City of Portland, Maine - Building or Use Permit Application
 389 Congress Street, 04101 Tel: (207) 874-8703, Fax: (207) 874-8716

Permit No: 05-0747	Issue Date:	CBL: 003 L00300C
------------------------------	--------------------	----------------------------

Location of Construction: 94 Beckett St	Owner Name: Scott Stanley J &	Owner Address: 21 Dudley St	Phone:
Business Name:	Contractor Name: Michael Dube	Contractor Address: 9 spring st Brunswick	Phone 2077984738
Lessee/Buyer's Name	Phone:	Permit Type: Additions - Commercial	Zone:

Past Use: Residential 3 unit	Proposed Use: Residential 3 unit repair / replacement of fire escape, door, window and deck	Permit Fee: \$93.00	Cost of Work: \$7,850.00	CEO District: 1
Proposed Project Description: Repair / replacement of fire escape, door, window and deck		FIRE DEPT: <input type="checkbox"/> Approved <input type="checkbox"/> Denied	INSPECTION: Use Group: Type	
		Signature: _____		Signature: _____
PEDESTRIAN ACTIVITIES DISTRICT (P.A.D.)				
Action <input type="checkbox"/> Approved <input type="checkbox"/> Approved w/Condition <input type="checkbox"/> Denied				
Signature: _____ Date: _____

1/2" = 1 FOOT

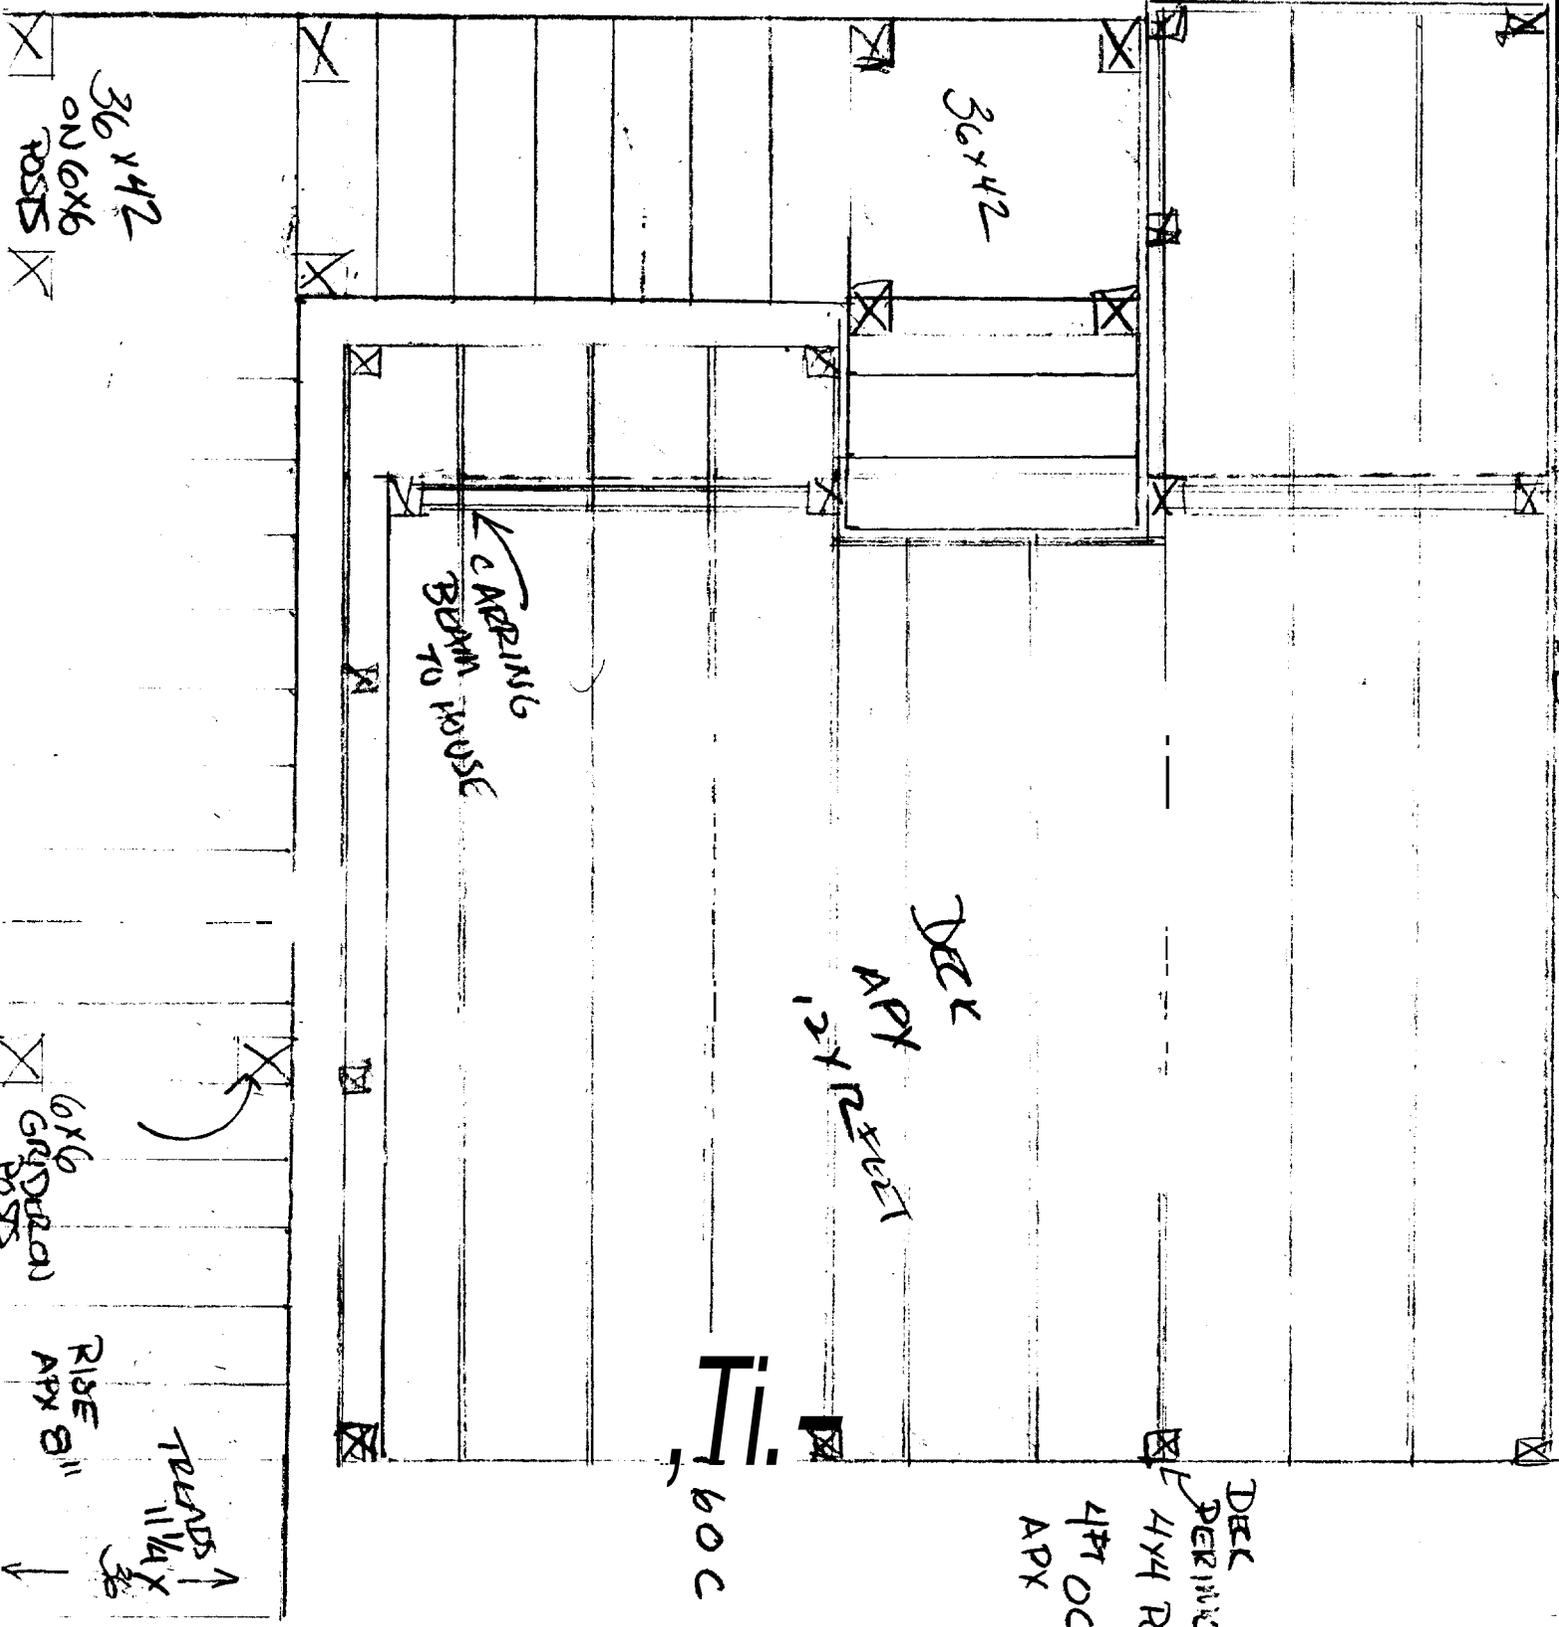
1) The net tread is allowed at 10.75 inches to make the structure fit on the lot. Per MJN			
2) All Guards Must be 42 inches with openings less than 4 inches with graspable rails on both sides that are between 34 inches and 38 inches above the leading edge of the tread.			
Dept: Fire	Status: Approved	Reviewer: Jay Kelley	Approval Date: 06/28/2005
Note:			Ok to Issue: <input checked="" type="checkbox"/>

Comments:
6/29/2005-mjn: Plans do not comply with building code standards, redraft required, need more detail, Placed on hold for a bit, Builder notified/owner notified

DEPT. OF BUILDING INSPECTION
 CITY OF PORTLAND, ME
 AUG 5 2005
 RECEIVED

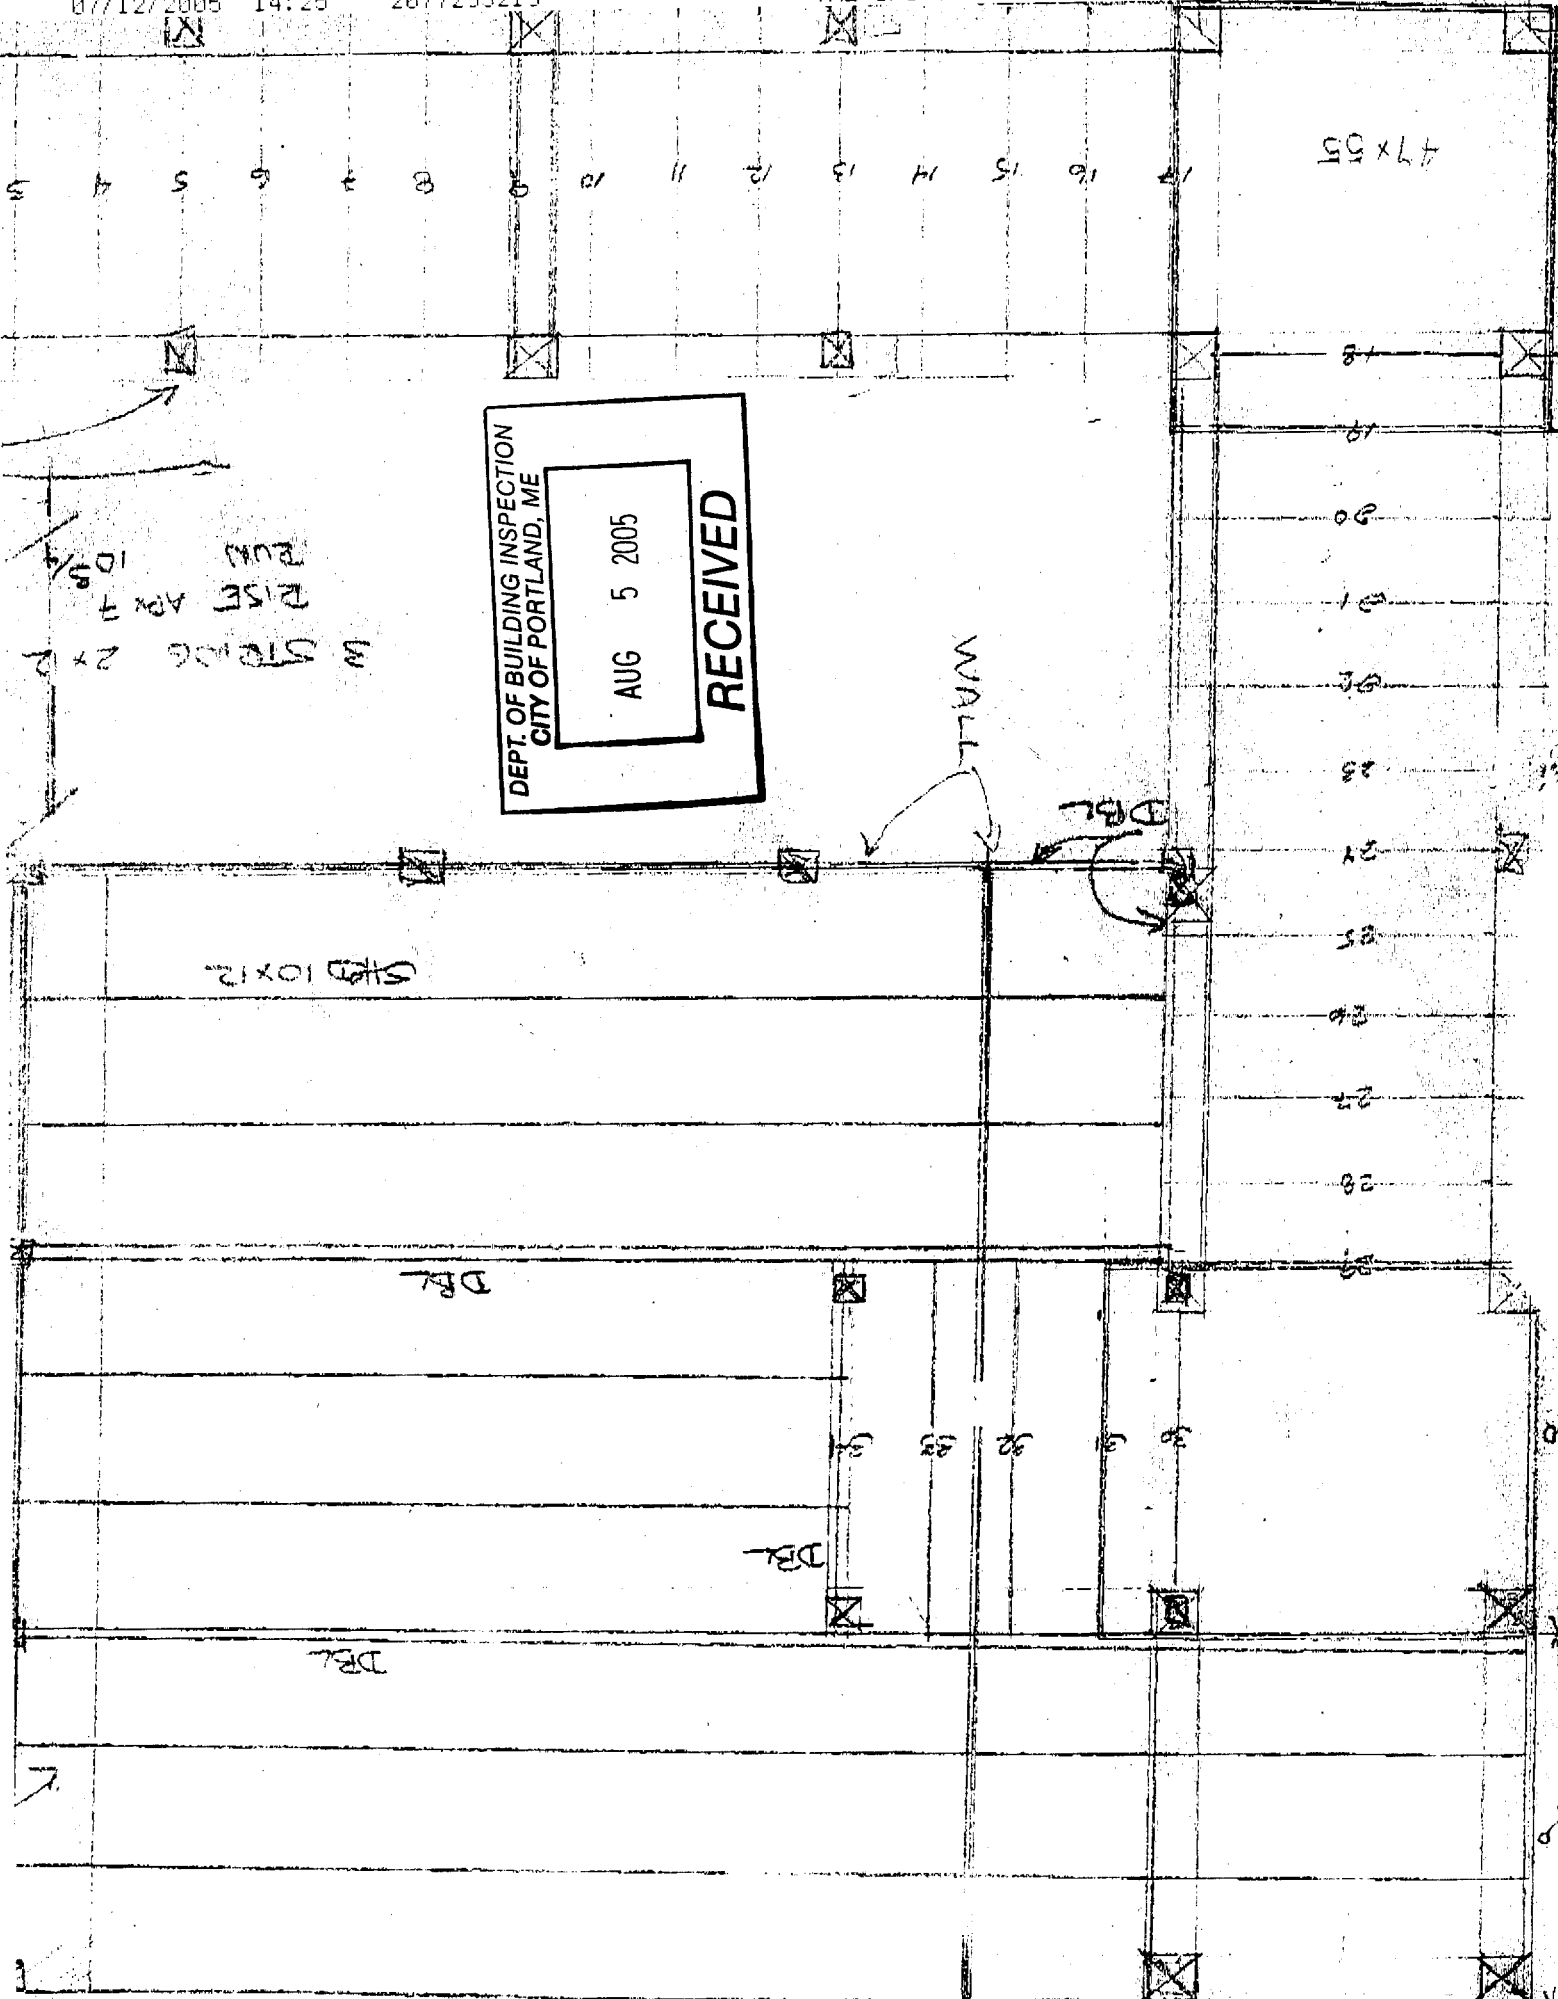
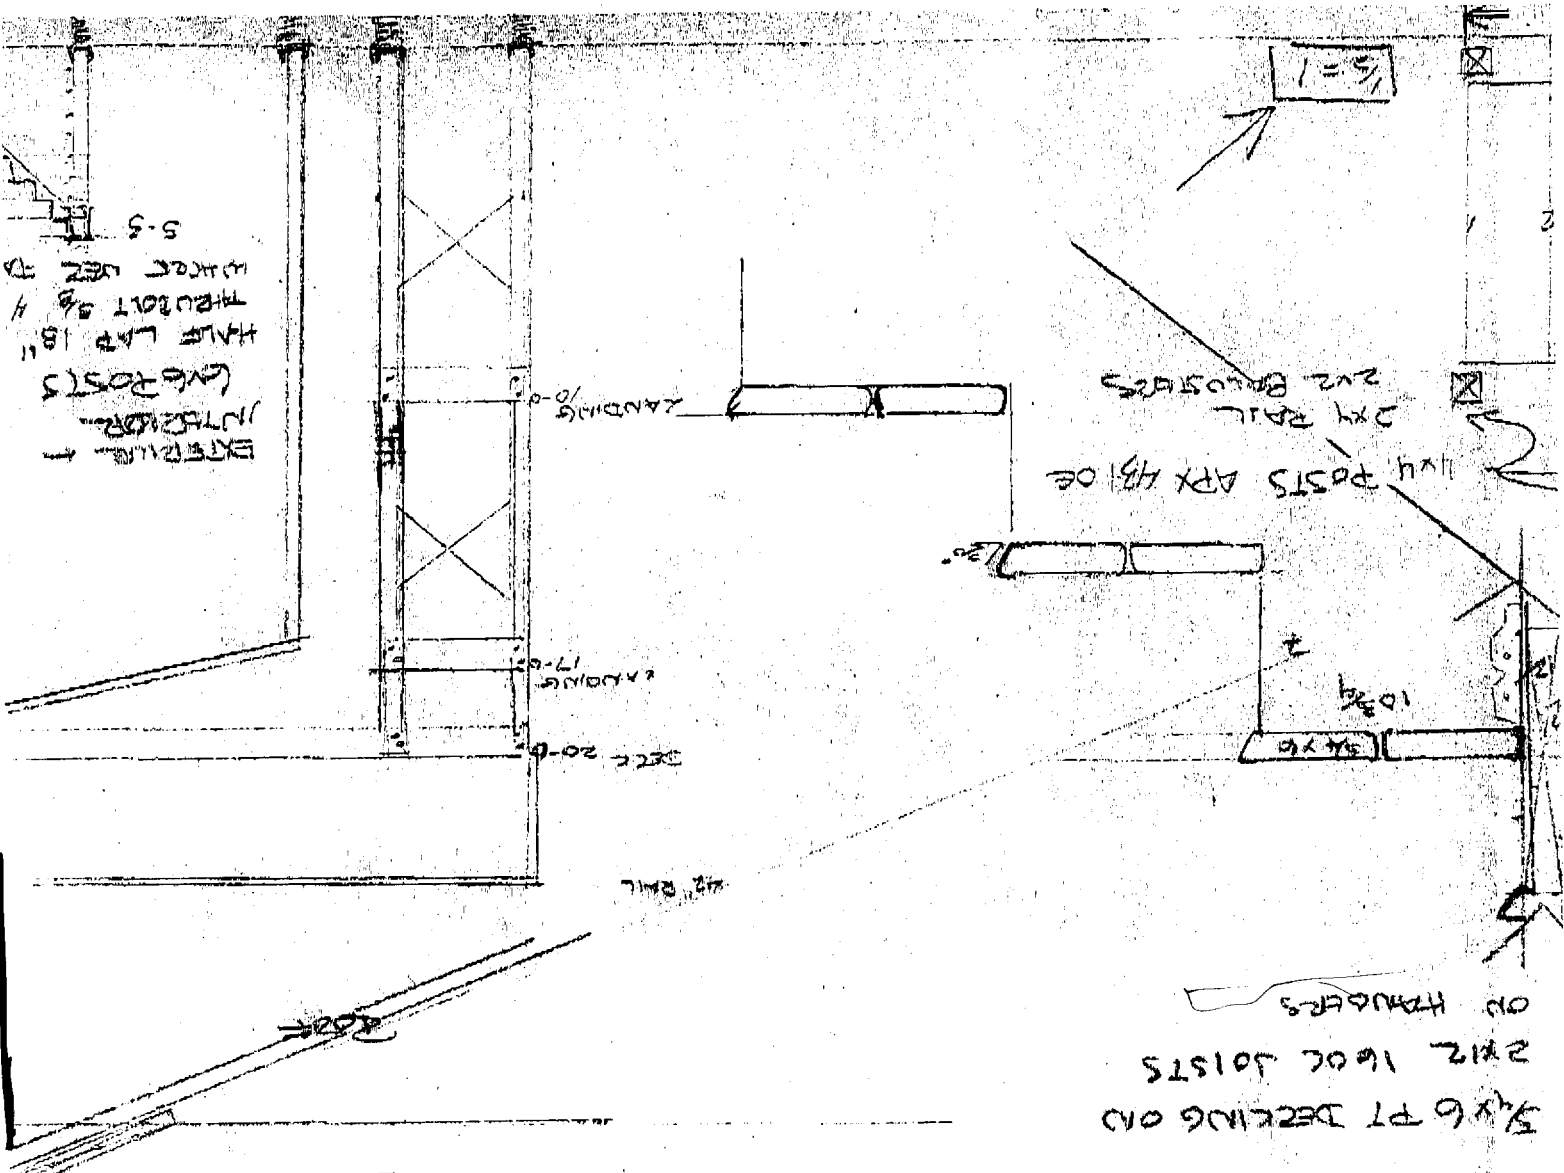
Dept: Zoning	Status: Approved with Conditions	Reviewer: Marge Schmuckal	Approval Date: 06/23/2005
Note: 7/12/05 Mike N gave back to me - the stairs are being changed to the minimum necessary to meet fire & building codes - rear lot line affected - ok under 14-440 & 14-433			Ok to Issue: <input checked="" type="checkbox"/>
